# CITY OF ALBUQUERQUE

August 17, 2022

**Re: Townhouse**  
**623 14<sup>th</sup> St. NW**  
**Traffic Circulation Layout**  
Architect's Stamp 07-11-22 (K13-D083)

Based upon the information provided in your submittal received 07-15-22, the above referenced plan cannot be approved for Building Permit until the following comments are addressed:

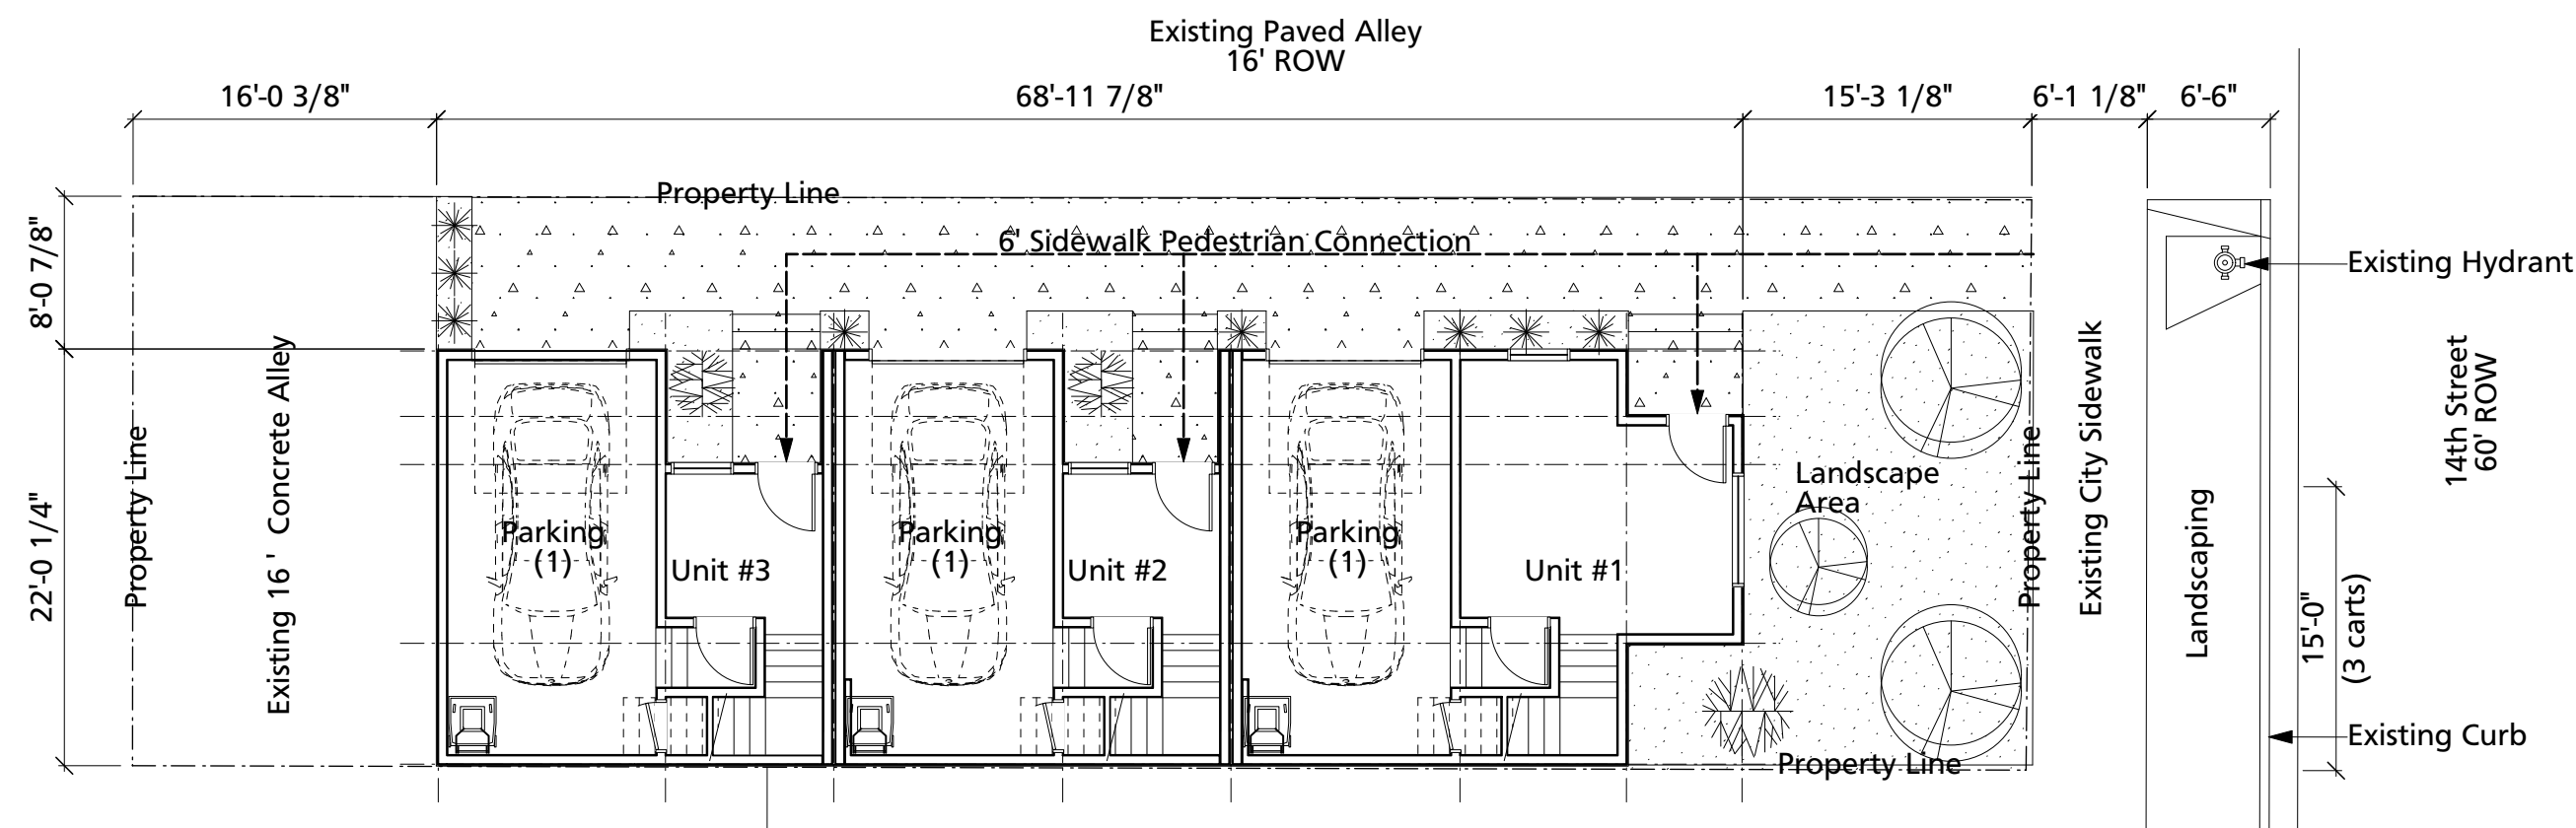
1. Provide the dimensions (width and length) for all the proposed parking spaces.
2. Provide shared access agreement with the property at the north side of your site.

3. Please define the pedestrian pathway from the public sidewalk to the building entrance, are there any ramps? If so, please provide all the proposed ramps details.

4. Please provide a sight distance exhibit
5. Show the clear sight triangle and add the following note to the plan: "Landscaping and signage will not interfere with clear sight requirements. Therefore, signs, walls, trees, and shrubbery between 3 and 8 feet tall (as measured from the gutter pan) will not be acceptable in the clear sight triangle. Please see attached Intersection sight triangle.

6. Please specify the City Standard Drawing Number when applicable.
7. Add a note stating "All broken or cracked sidewalk must be replaced with sidewalk and curb & gutter." A build note must be provided referring to the appropriate City Standard drawing.
